December 2, 2016

SUBJECT: **Modification Request of Section 404 Regional General Permit No. 31 and Section 401 General Water Quality Certification No. 3886** for the proposed Interstate 85 (I-85) Widening and Interchange Improvements from north of NC 73 (Davidson Highway / Exit 55) to north of SR 2180 (Lane Street/Exit 63), Cabarrus & Rowan Counties, Divisions 9 and 10. Federal Aid Project No. FANHIMF-085-2(61)55, TIP Project No. I-3802A.

The permit drawings for these three sites have been revised to depict the additional bank stabilization at Site 2, temporary impacts at Site UC-1, and the additional bank stabilization at Site 18. They have been included in this modification request along with the revised impact summary tables.

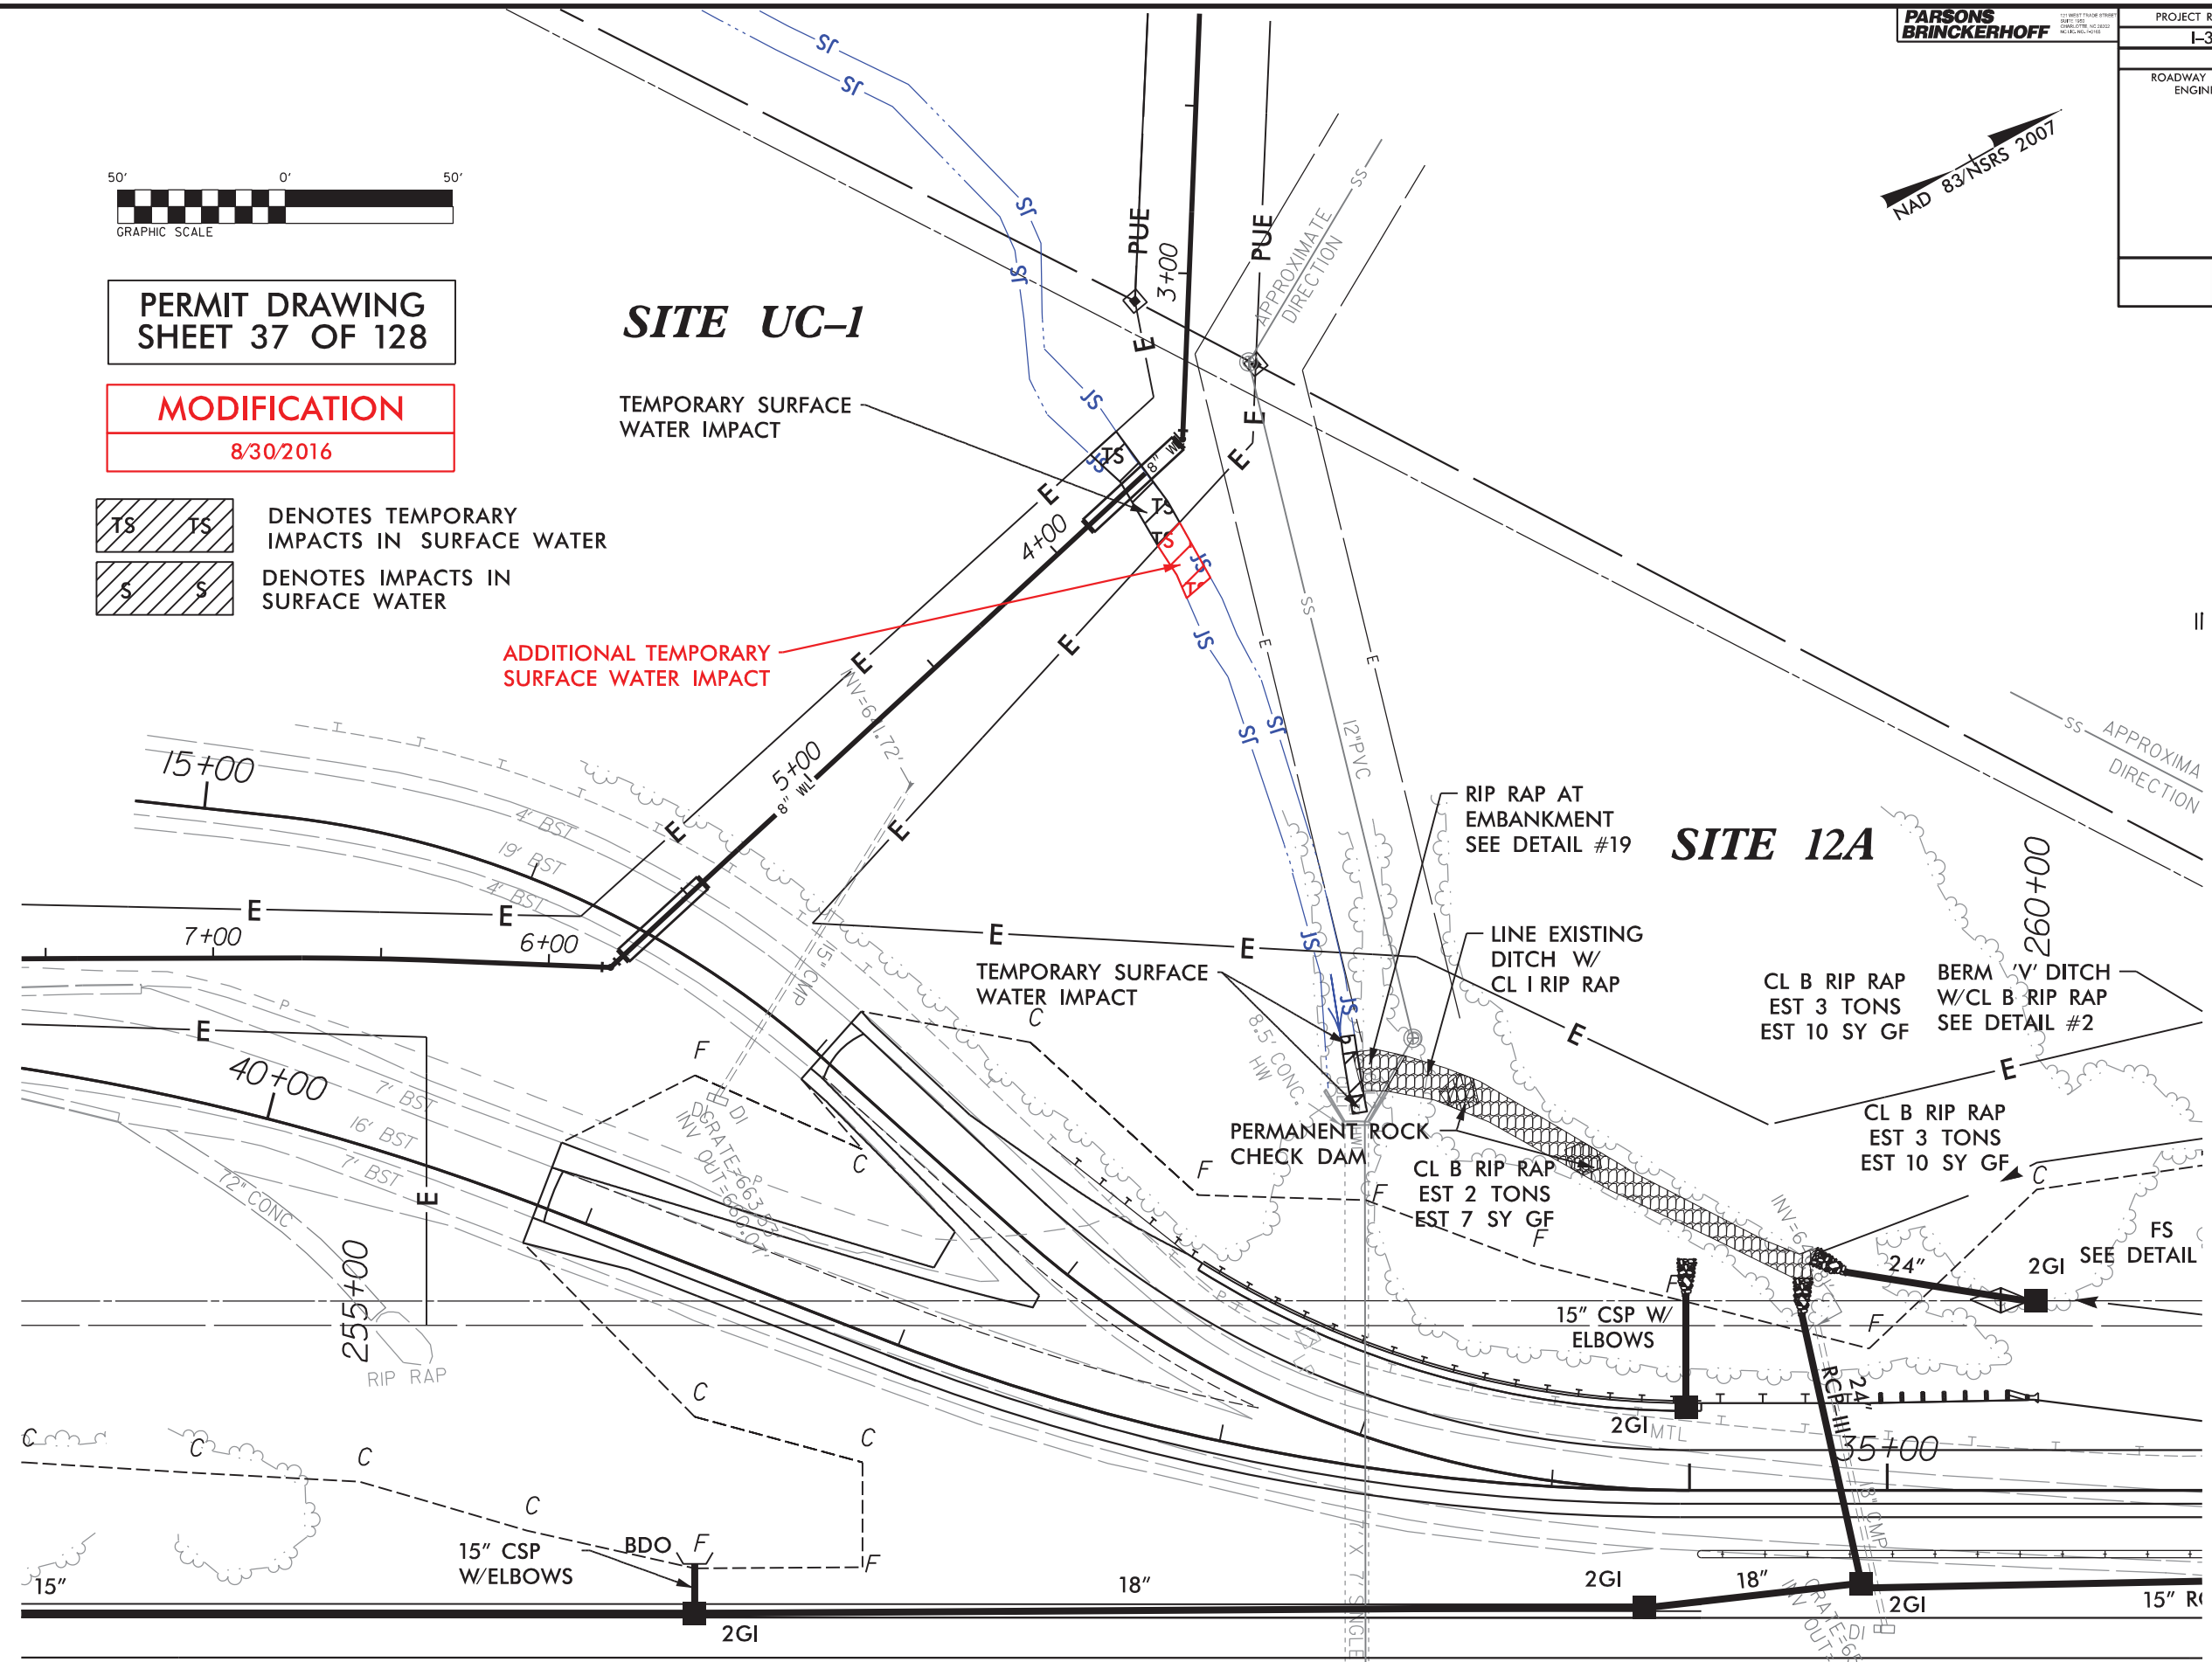
On July 19, 2016, representatives from NCDOT met on site with Ms. Donna Hood to conduct a project review. During the site meeting Ms. Hood measured additional unpermitted temporary impacts of approximately 16 feet in length to Site UC-1. During the site prep for the installation of the proposed waterline, additional areas were cleared along the stream banks. The clearing impacts were necessary for the installation of the waterline and to allow for a dry work area. Ms. Hood recommended that these additional impacts be included in the next permit modification. Ms. Hood contacted Ms. Crystal Amschler (USACE) via email on September 21, 2016 to inform her that she had observed the aforementioned impacts and had made recommendations to the contractor regarding a time frame for submission of the modification request.

The temporary surface water impacts associated with the waterline installation overrun resulted in an additional 19 linear feet of temporary stream impact per the contractor's field measurements (this is the same area as the 16 feet referenced above, but a more

accurate measurement). The proposed impact total for Site UC-1, including the previously-permitted impacts and the currently unpermitted impacts are 56 linear feet of temporary stream impacts. No other changes to permitted wetland and stream impacts are proposed for Site UC-1.
